CONSULTATION UNDER TOWN AND COUNTRY PLANNING ACT 1990

Application Number	PL/2023/01622/PPFL
Address	Four Oaks Back Lane Meriden Solihull CV7 7LD
Proposal	Retrospective change of use of the ancillary swimming pool outbuilding at Four Oaks House, CV7 7LD, for commercial use between the houses of 09:00 and 17:45 on weekdays.
Case Officer	Benn Watkinson

Date comments sent	18/08/23
Name of consultee department	Highways
Consultation response author	Gurdip Nagra

Crown copyright 2014. Supplied by UKPlanningMaps.com a licensed Ordnance Survey partner (100054135).  
**BLOCK PLAN 1:500**

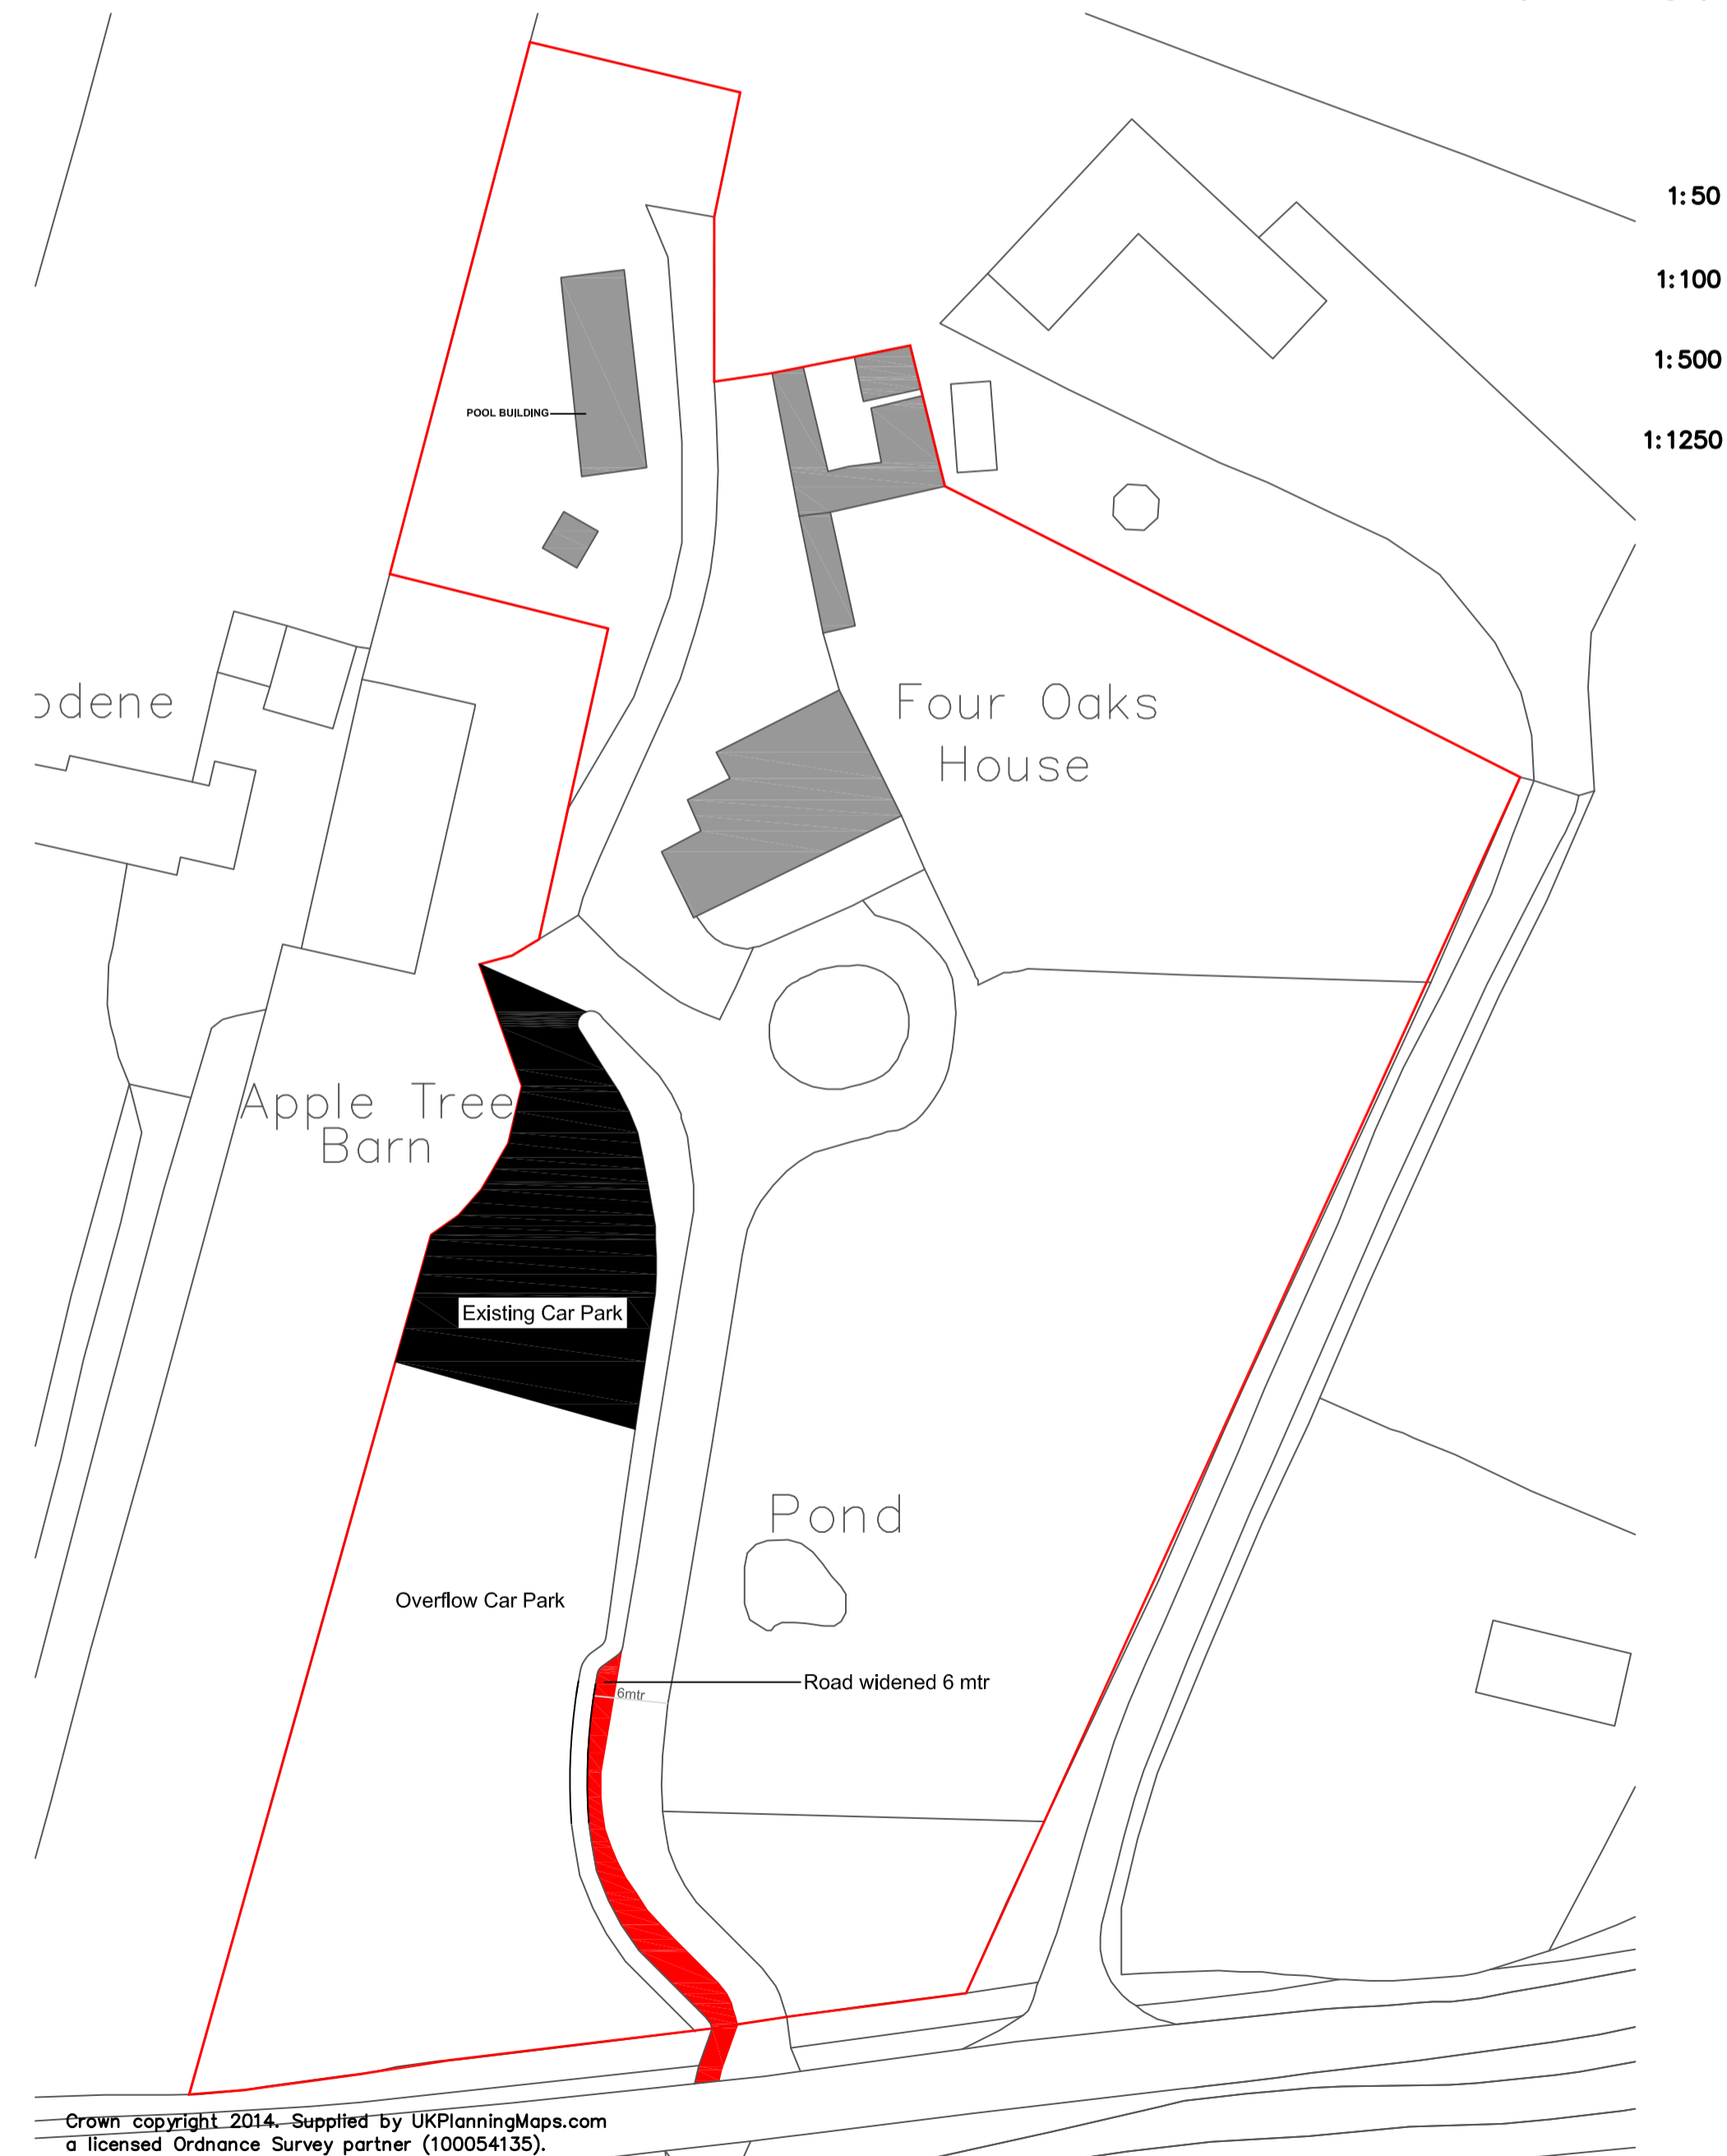
The proposed access to be widened off Back Lane has a 40 mph speed limit that requires visibility splays of 90m to be provided to the near edge of the carriageway, when measured 4.5m back from the edge of the carriageway.

- a) The application site is not considered to be in an accessible location and therefore fails to accord with Policy P7 of the Solihull Local Plan 2013.
2. The proposed access off Back Lane has a 40 mph speed limit that requires visibility splays of 90m to be provided to the near edge of the carriageway, when measured 4.5m back from the edge of the carriageway.

- a. measure 4.5 metres from the carriageway in the centre of the entrance or driveway
- b. draw lines to the left and right until they reach the opposite end of the carriageway
- c. any space within the resulting two triangle areas must remain free of any obstruction above 1 metre in your plans
